July 3, 1986

RE: REVISED DRAINAGE PLAN FOR FASHION VILLA (H-22/D49)  
REVISION DATE JUNE 27, 1986

**DRAINAGE AND GRADING PLAN
FOR
FASHION VILLA**

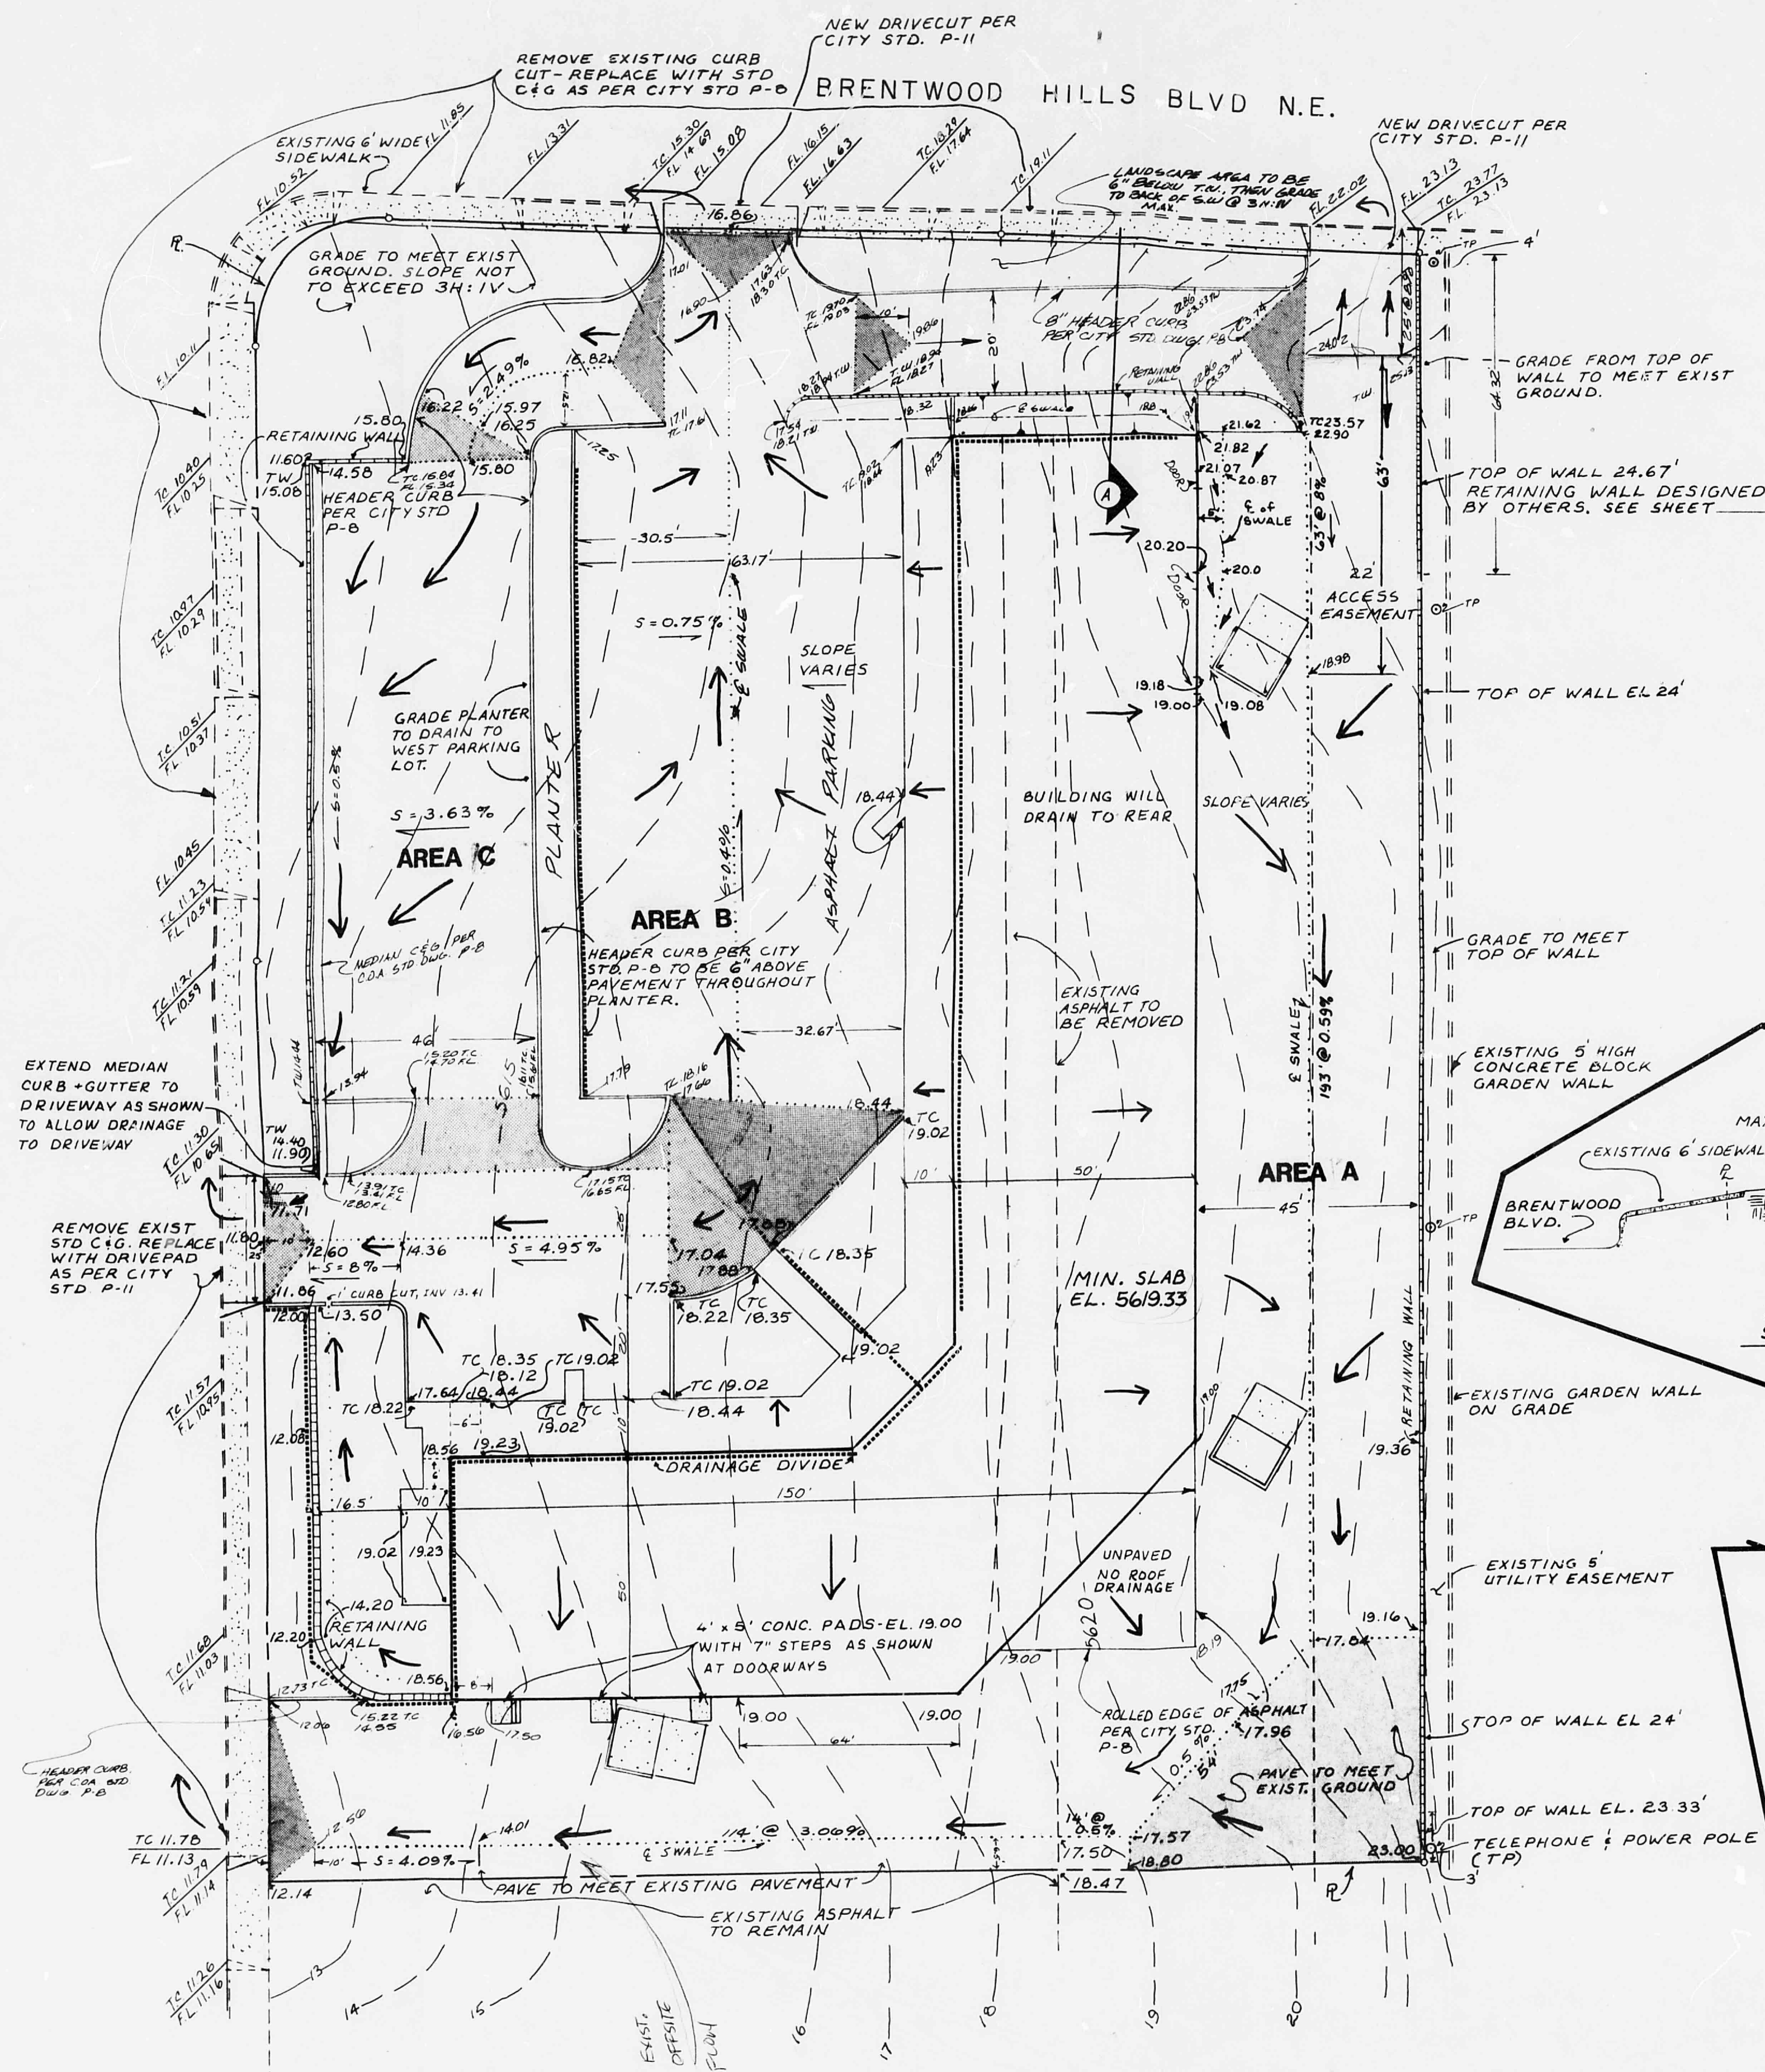
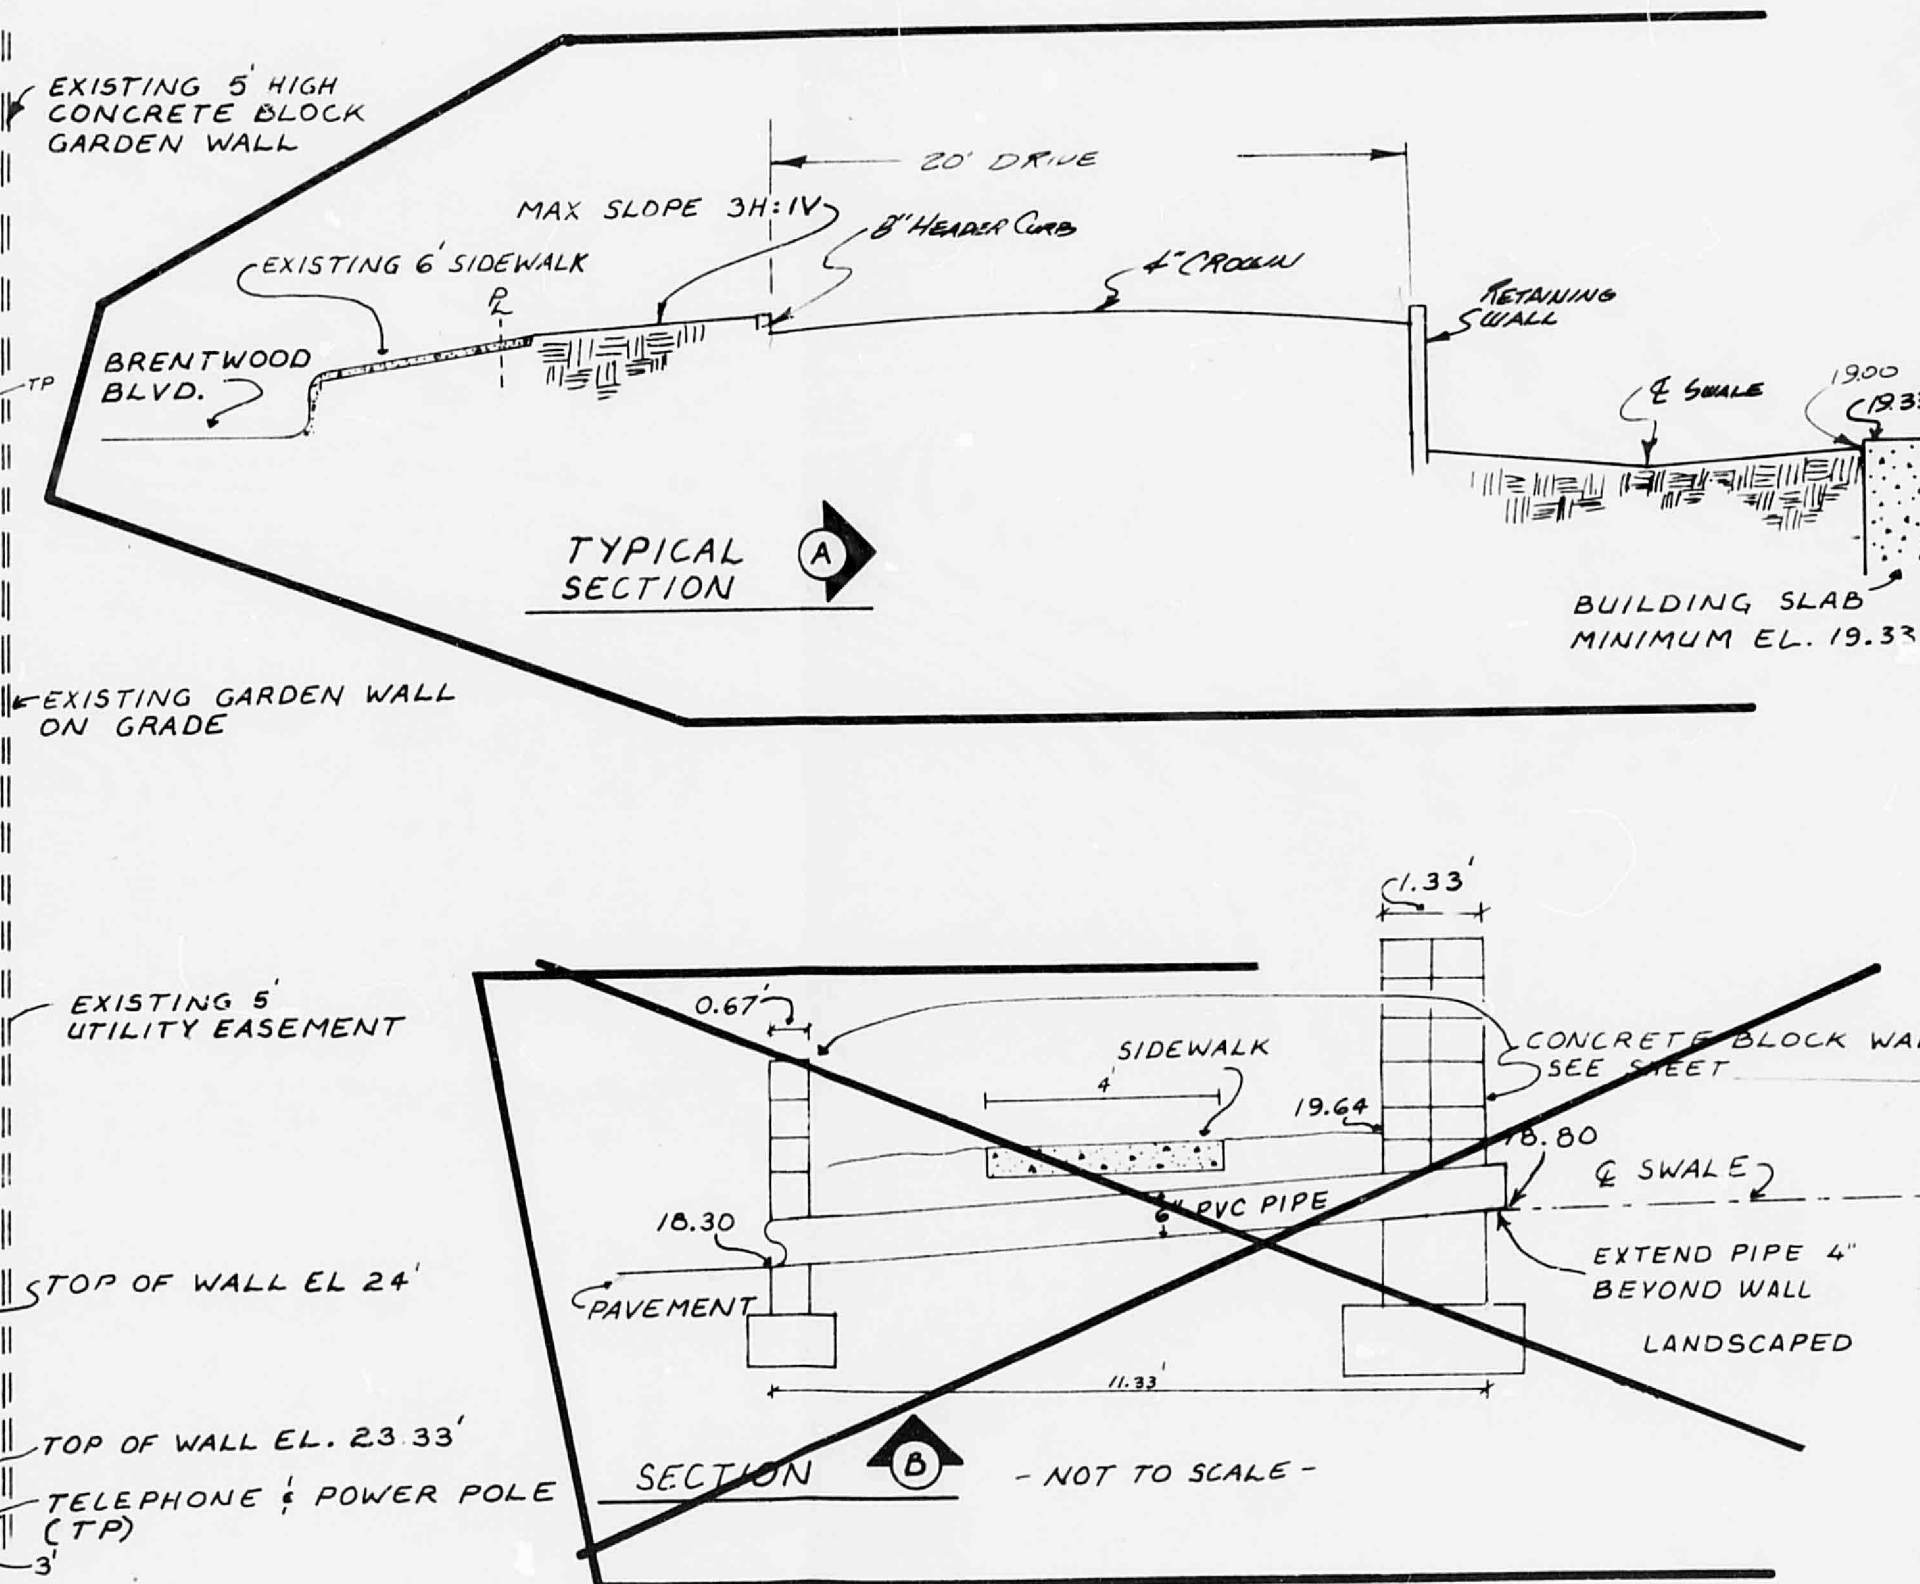
Please be advised that the flood proofing is only protection against the 100-year flood, but the site is still considered to be encroached by the flood zone and insurance may be required.
